FIRE HYDRANT ASSESSMENT REPORT

SELL & PARKER, BLACKTOWN

45 Tattersall Rd, Kings Park NSW 2148

Date: 15 June 2020
Revision: 2
Issue: Issued to Client
Ref. No.: 21000_FHAR

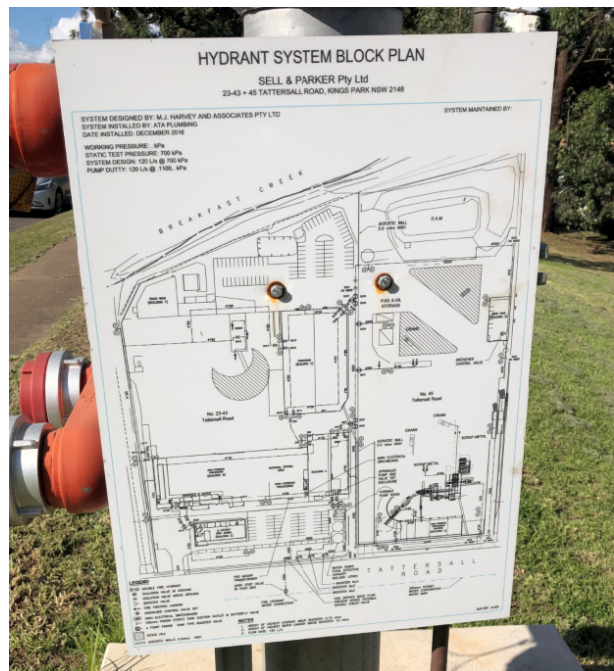
It was observed that the existing booster valves are not secure or locked in the open position.

1. The existing booster assembly is non-compliant due to the booster valves not being secure or locked in the open position.
2. The booster inlet pipes do not have an isolation valves downstream of the booster inlets. Booster inlet pipes are required to have an isolation valve if the head at the inlets can be greater than 50kPa due to the pumps running.
3. No signage to identify the booster assemblies in accordance with Clause 7.10 of AS2419.1 – 2005.
4. FH Block plan has incomplete and incorrect information in accordance with Clause 7.11 of AS2419.1 – 2005
5. The fire brigade hardstand was observed to be non-compliant at the time of inspection due the fire brigade booster assembly being obstructed by parked cars.
6. Boost and Test Pressure signage is not provided for the boosters.

1. The booster valves shall be secured in the open position with a padlock openable by the fire brigade 003 key.
2. Isolation valves shall be provided downstream of the booster inlets.
3. Provide separate stands for signage of

the 'FH Booster' and must be adjacent the suction and inlet points to avoid confusion with the adjacent sprinkler booster.

4. Revise Block plan layout to show the actual configuration of the system including FH30 outside Building B, north arrow, connections for fire monitors, standard of compliance and electrical substation. The location of FH25 adjacent the weighbridge shall be updated on the block plan to reflect the accurate location.
5. The fire brigade hardstand shall not be used as parking. Request council to move no-parking sign beyond booster assembly to keep front of boosters clear at all times.
6. Provide a fade-resistant or engraved sign indicating boost and test pressure in kPa, marked in upper case lettering not less than 25mm in height

Location of FH24

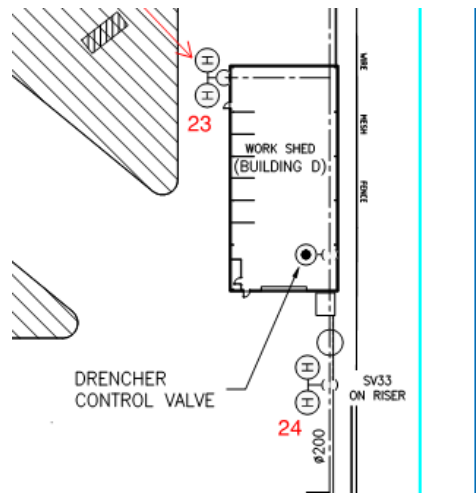
It was observed during the inspection that FH24 was obstructed by existing sheds and did not have a cover.

1. The existing fire hydrant system is not compliant due to the fire hydrant accessibility being obstructed by the existing sheds.
2. The existing fire hydrant system is non complaint due to the fire hydrant outlet without having a protective cap to block debris and other contaminants from entering the pipes.

1. The fire hydrant shall be relocated to an accessible location in front of the sheds.
2. The fire hydrant shall be kept covered when not in operation. Caps shall be provided to missing fire hydrants.

Risers entering Building B from SV1 and SV2 without bollard protection

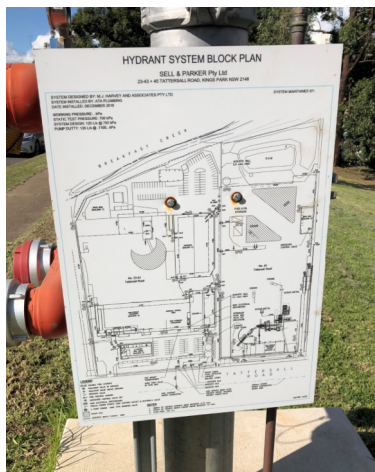
The existing fire hydrant system has pipework and in areas with moving vehicles, without protection of damage from the vehicles.

The existing fire hydrant system is non complaint because AS2419.1 requires fire hydrants and pipework to be located so that the fire hydrant system is protected from possible mechanical damage by vehicles. The following pipes are required to, but did not have any protection from physical damage:

- Risers entering Building B from SV19 and SV20
- Risers entering Building B from SV1 and

The risers serving Building B from shall be provided with bollard protection from moving vehicles.

Fire hydrant located within 10m of substation.

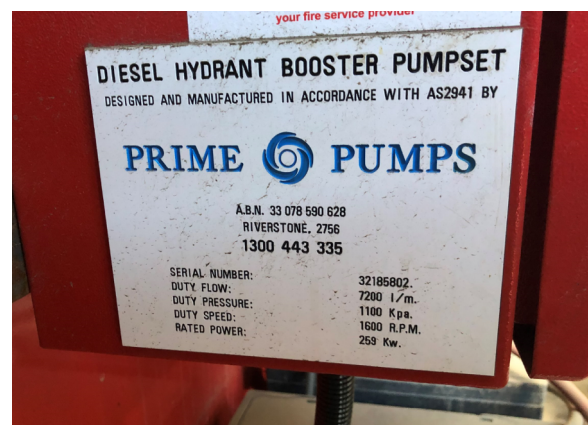
The existing fire hydrant located outside the site is located approximately 6 metres away from the existing substation.

AS2419.1-2005 requires fire hydrants to be located at a distance not less than 10m from high voltage equipment.

Relocate the fire hydrant to be at least 10 metres away from the existing substation.

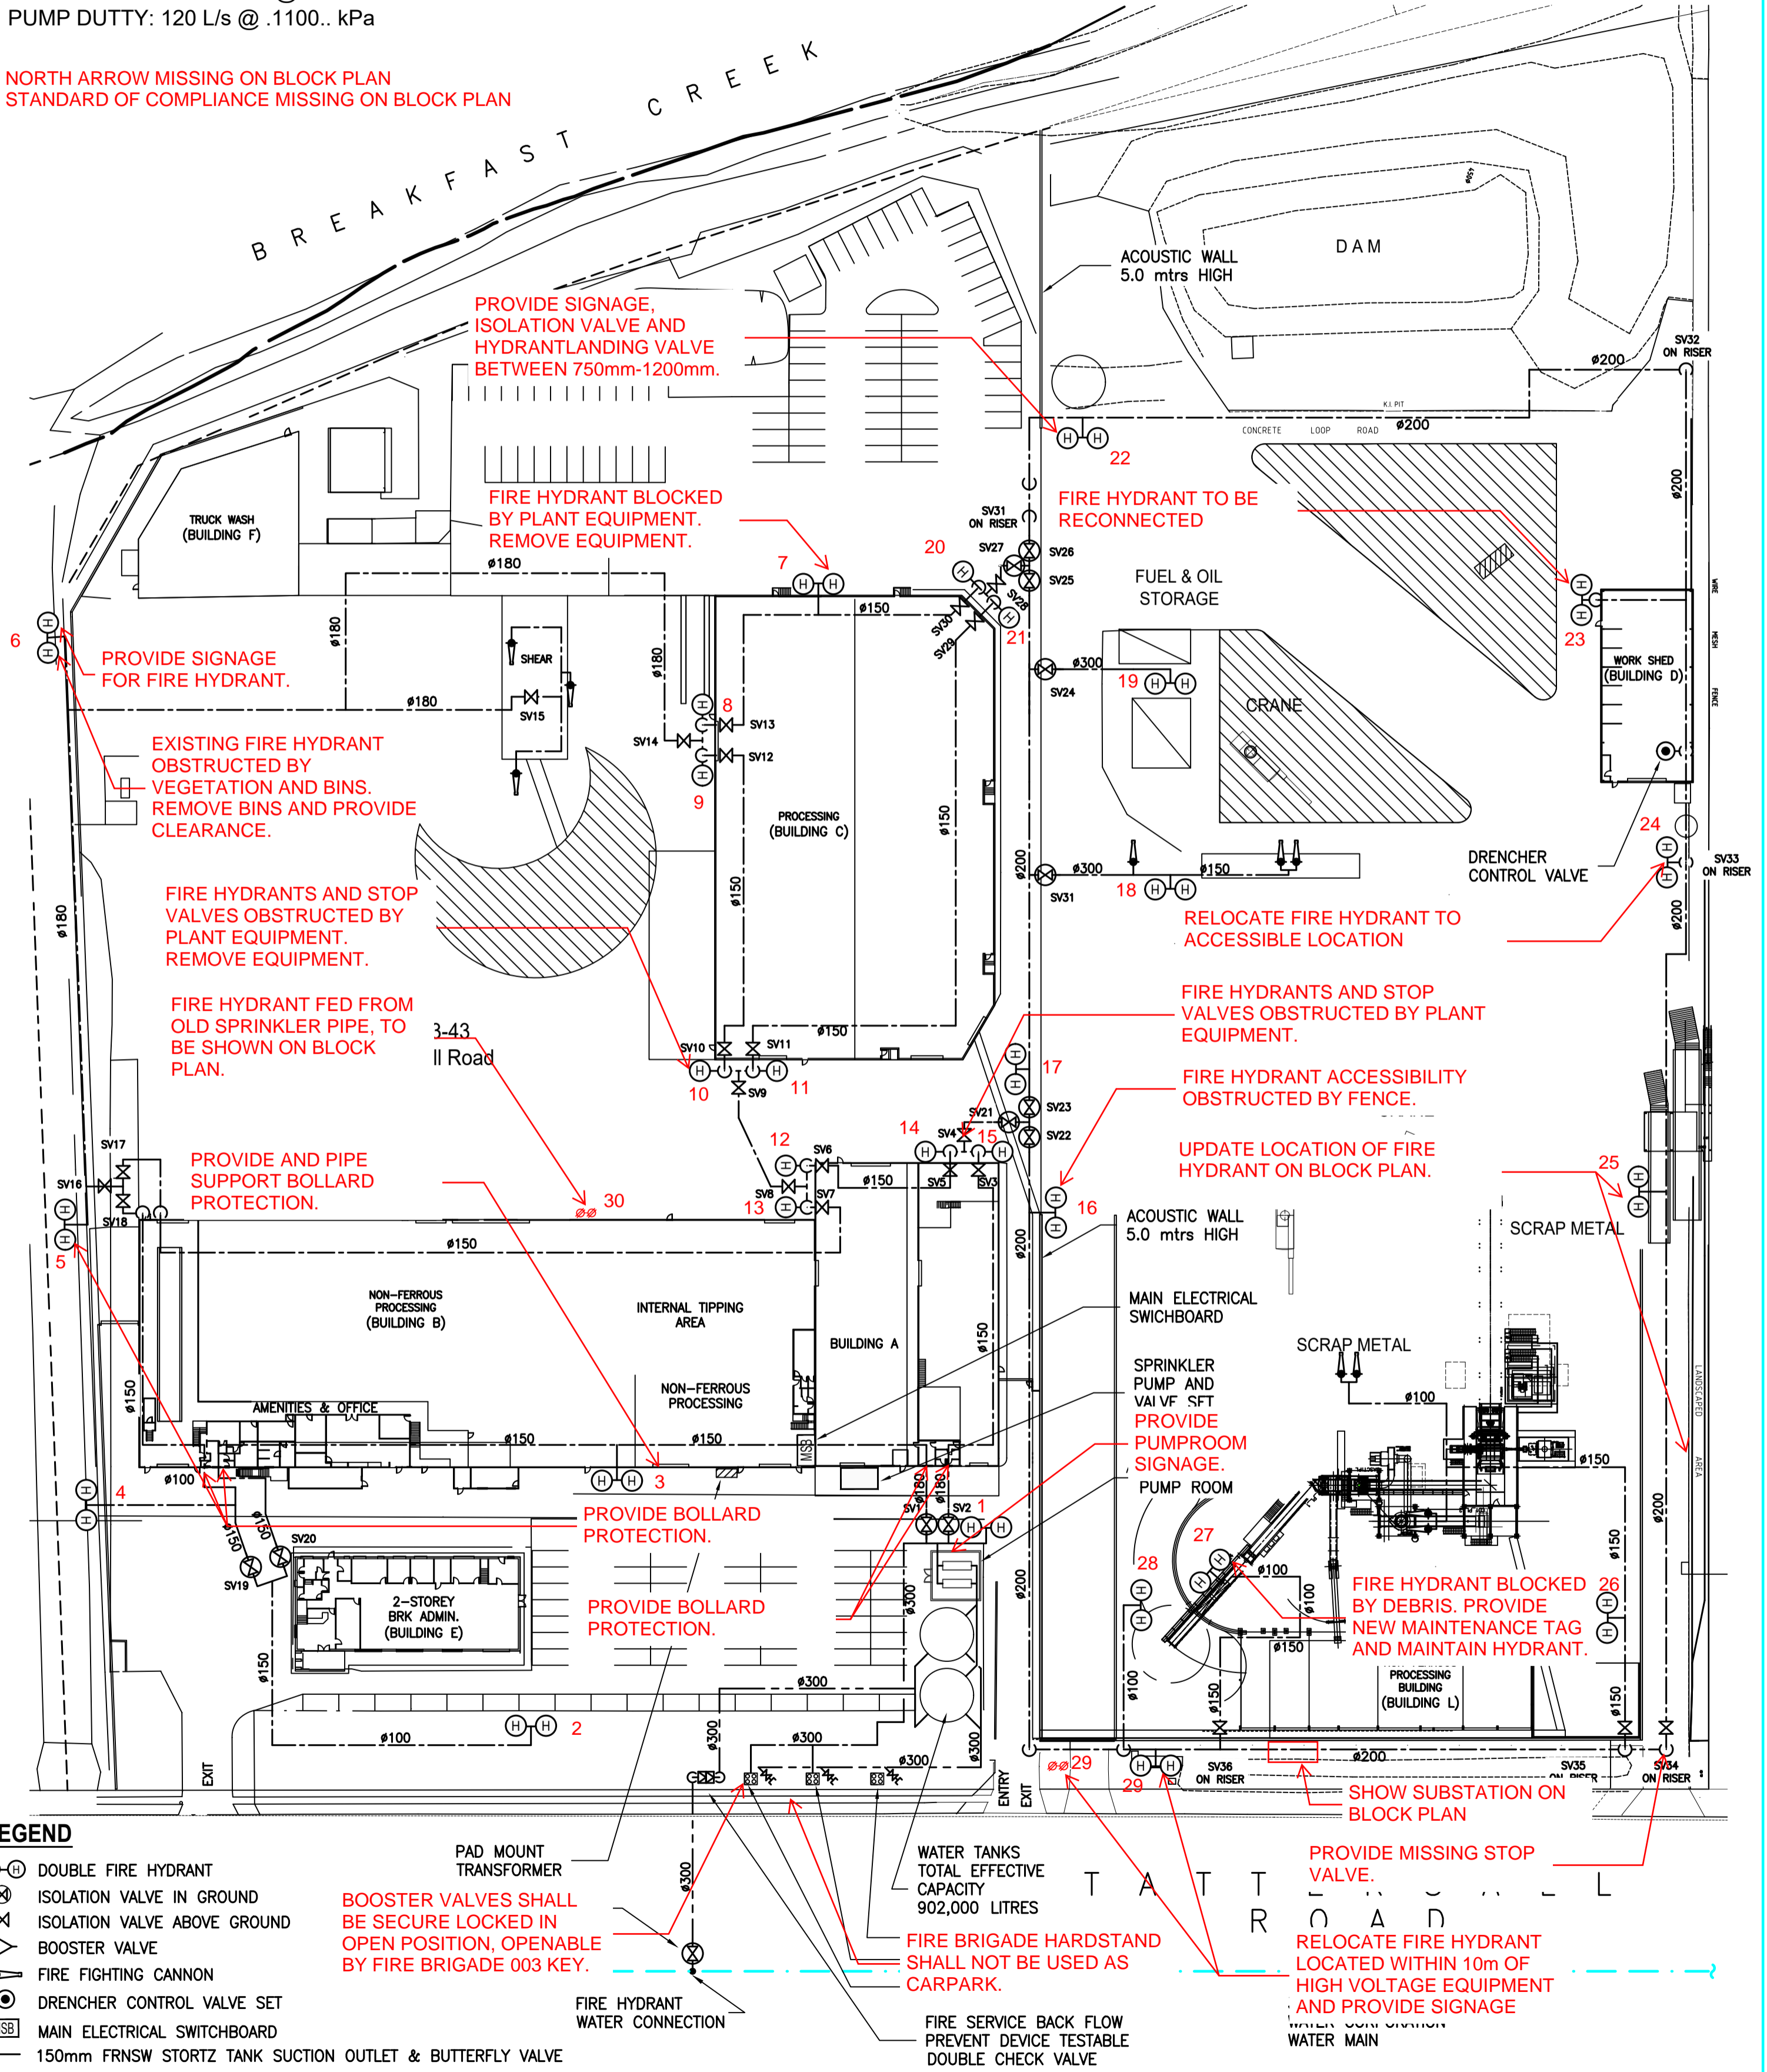
The fire hydrant block plan shall be updated to show the north arrow, electrical substation, standard of compliance and the external fire hydrant (FH30) supplied from an old sprinkler pipe, located adjacent Building B. Isolation valve SV34 shall be provided as per the fire hydrant block plan. Several above ground fire hydrant ring main isolating valves are not labelled. Label tags shall be provided to above ground isolating valve as per AS2419.1-2005.
